## **East Midlands Gateway Phase 2 ISH 3 Wednesday 13th May and Thursday 14th May 2026**

### **Summary of Verbal Representations from Protect Diseworth (PD)**

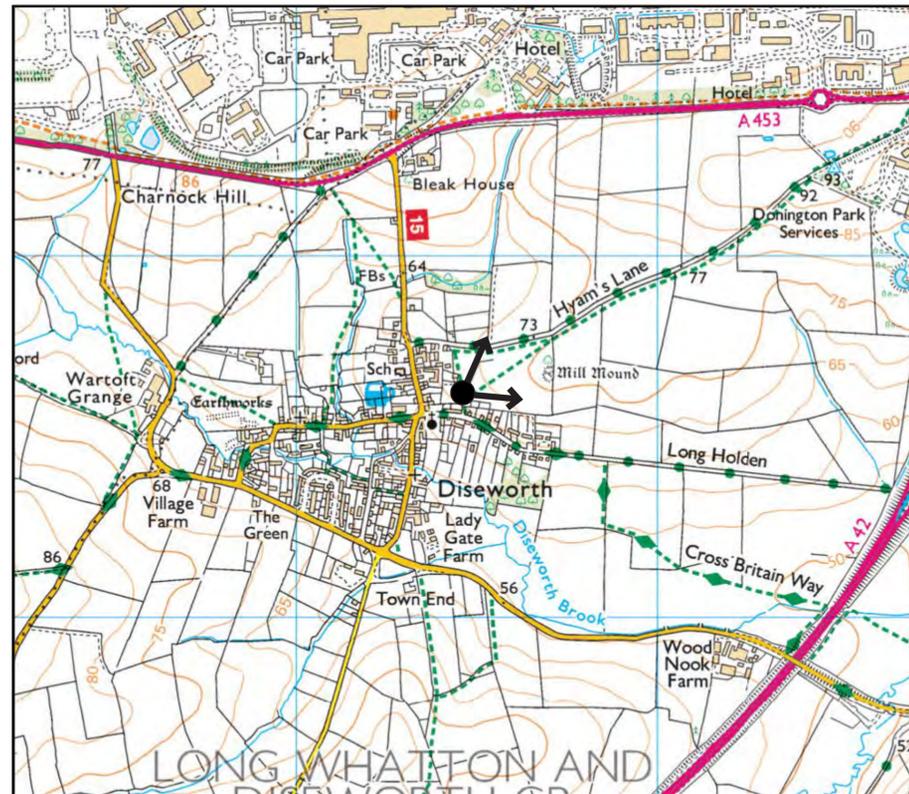
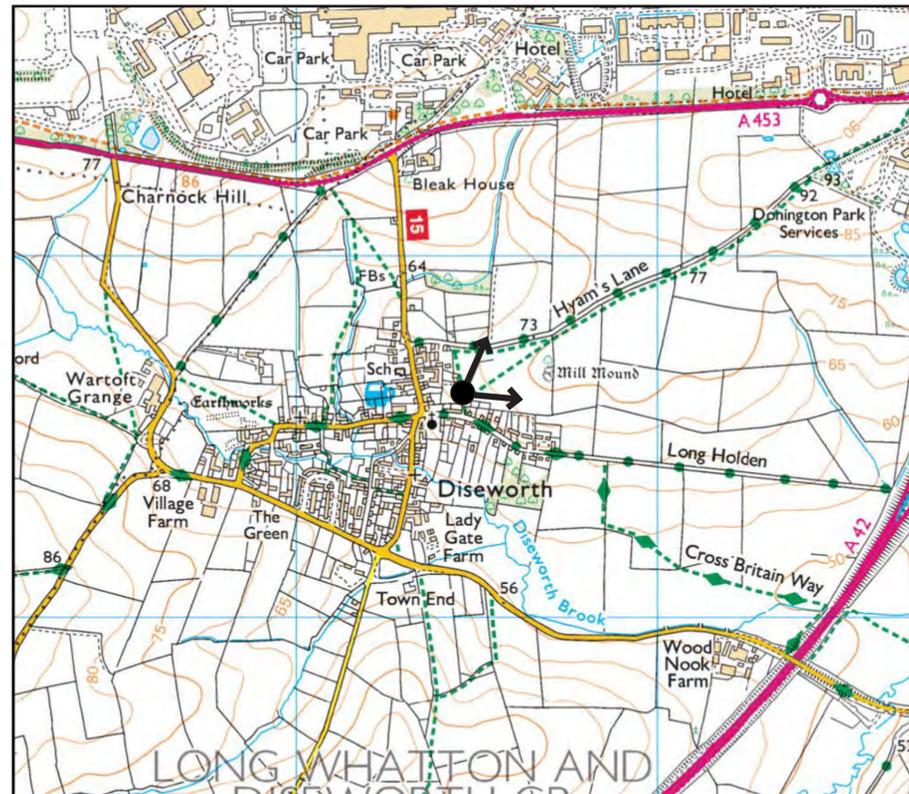
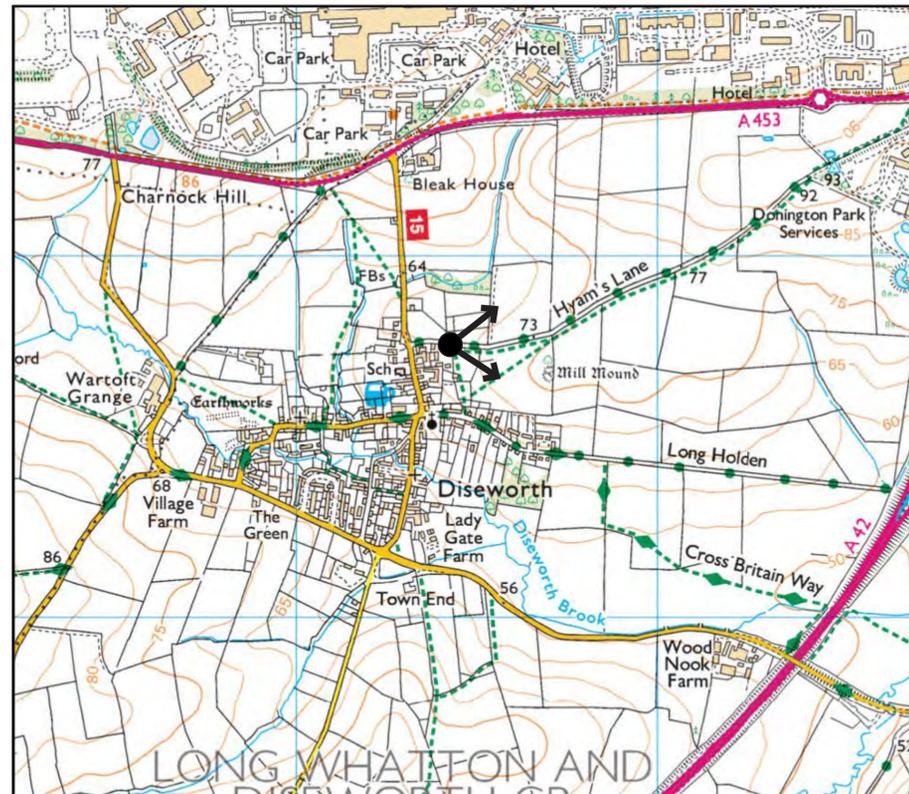
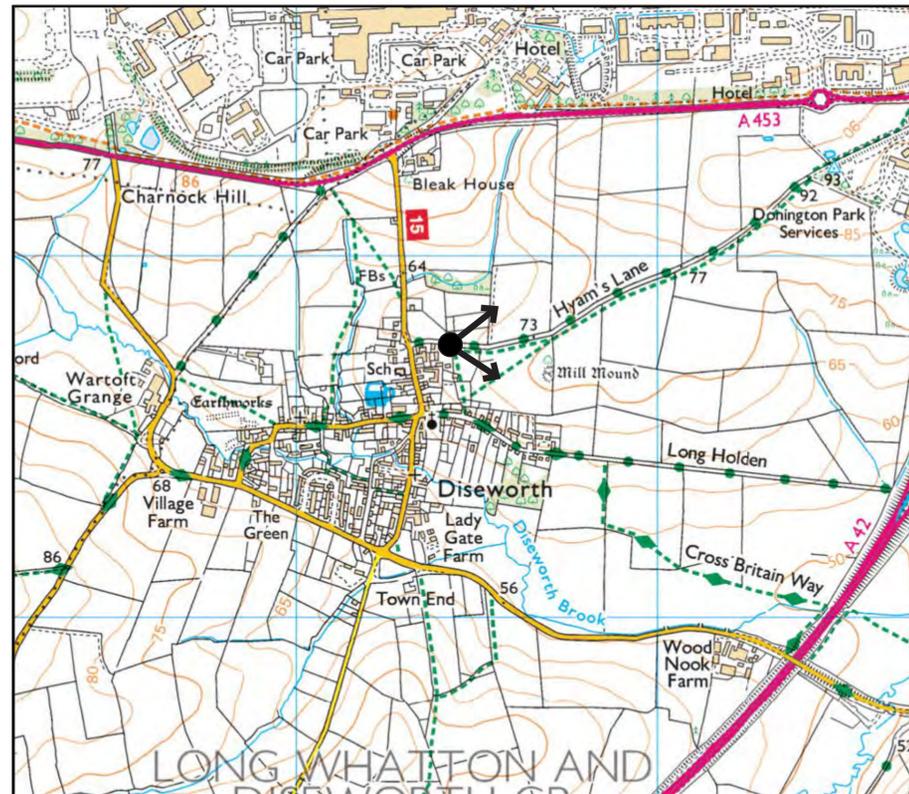
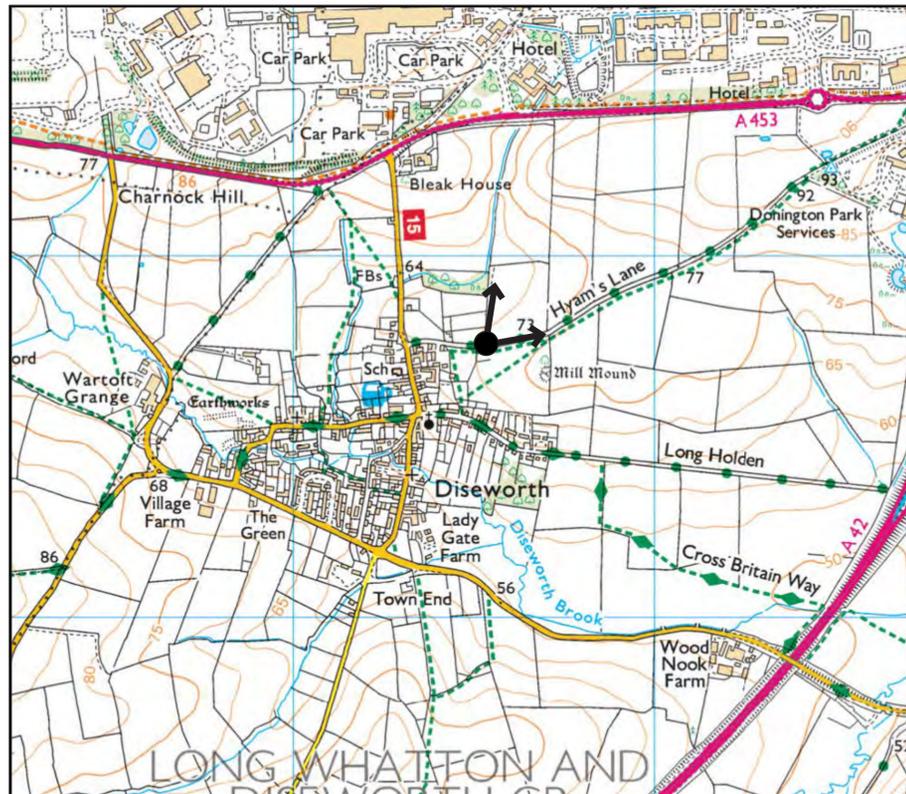
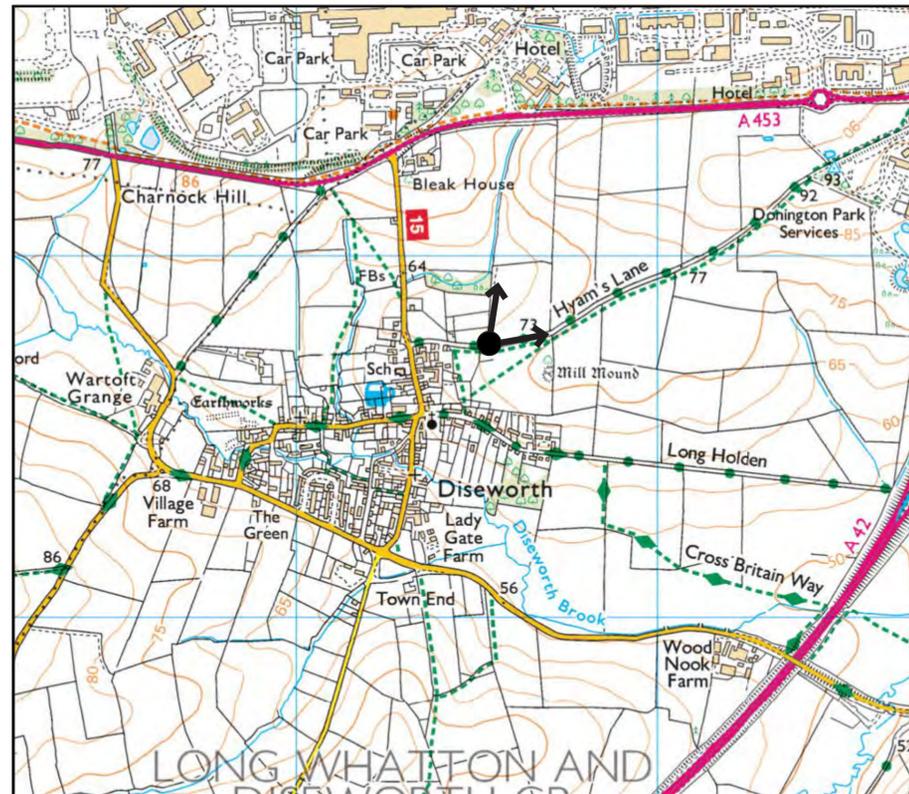
- The section heading (Paragraph 3.0 of Appendix 10a) says ‘Type 4 Photomontages’ but the text (Paras 3.1 and others) and the summary table (paragraph 3.14) both classify them as Type 3 under TGN 06/19.

- As such, it would appear to PD that the montages are not Type 4 they are in fact Type 3.
  - Paragraph 3.8 says surrounding context modelled from ‘LIDAR DSM 1m’ but the summary table says ‘LIDAR DTM 1m’. There is the same error in the night-time section.

- In order to have confidence in the reliability of the methodology which informs the assessment, the Applicant should address all apparent errors and deploy the use of type 4 visualisations, rather than type 3.

title **VP EMG1 e - PHOTOMONTAGE YEAR 0 (MCO)**

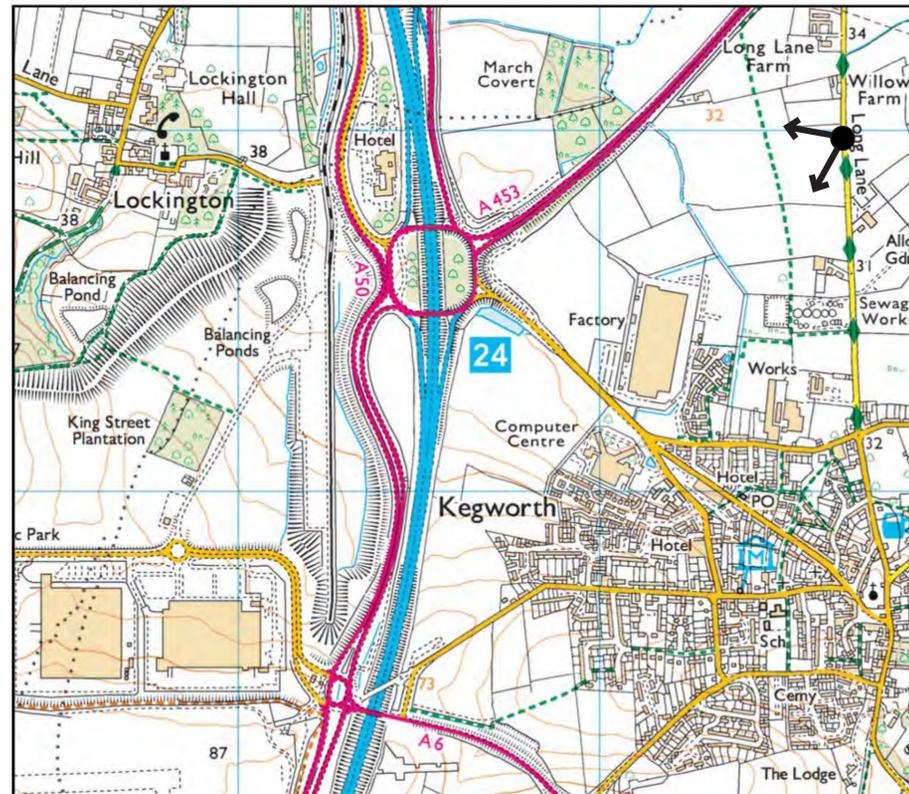
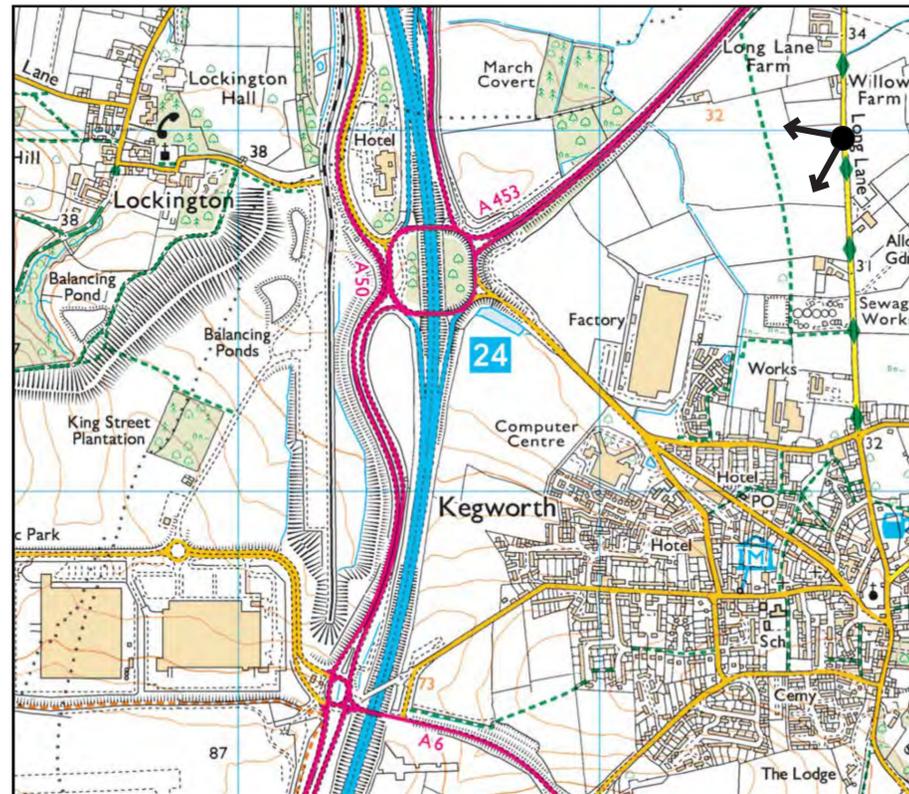
- EMG1e and all the night-time VPs are sub-3m accuracy (using a phone). They are noted as that, but none could be argued to meet Type 4. **So, in summary they are not Type 4.**
